CITY OF PORTLAND, MAINE
PLANNING BOARD

January 31, 2014

Project Name: Sheridan Street Apartments
Address: 152-156 Sheridan Street
Applicant: New Day Farm, LLC

Project ID: 2013-241
CBL: 12 P021001
Planner: Nell Donaldson

Drawing file: 1.  Original Plans / 09 C4.0 GRADING AND DRAINAGE.pdf

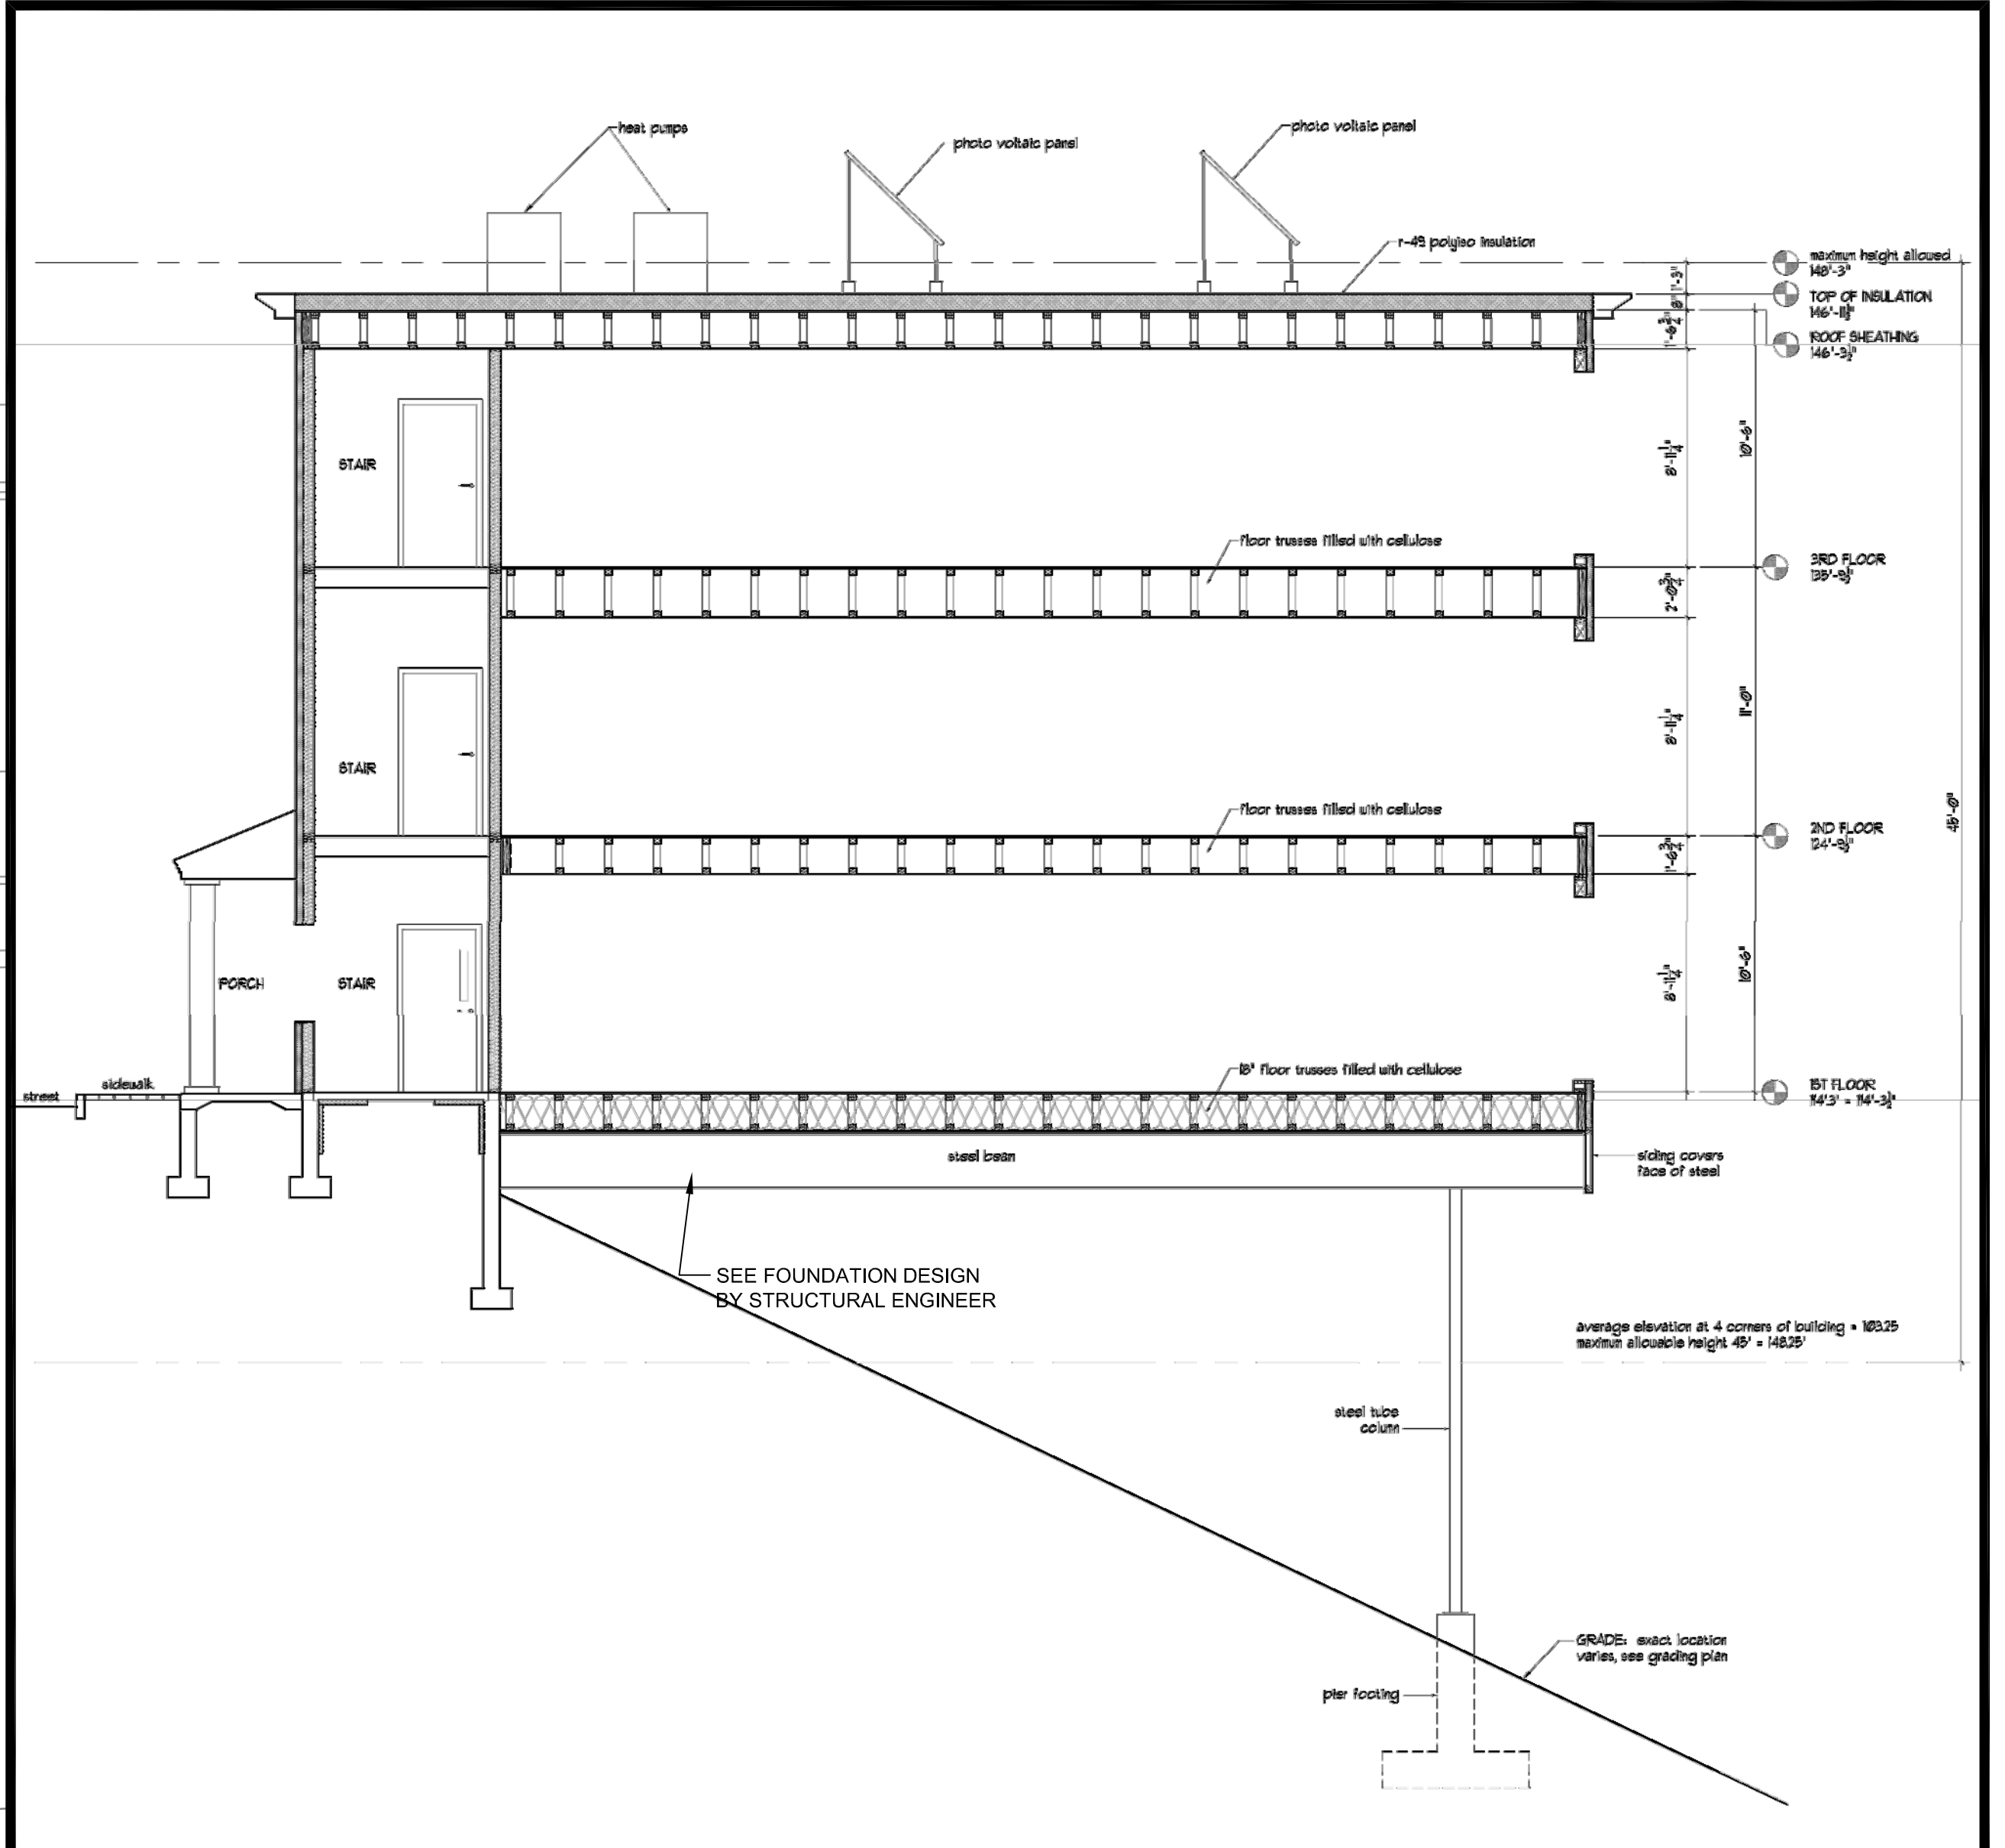
3. Should an alternative roof stormwater filter system be selected, the applicant shall provide additional performance and manufacturer information and revise Sheet C-4.0 accordingly for review and approval by the city's Department of Public Services;

I have reviewed the new information submitted on the C-4.0 grading plan. This plan shows the average grading around the building and then takes that average grade into consideration on the elevation plan showing the height of the structure. From average grade, the building height of the structure is a fraction over 43 feet. The maximum allowable building height in the R-6 zone is 45 feet. This structure is meeting the maximum height requirement for the R-6 zone.
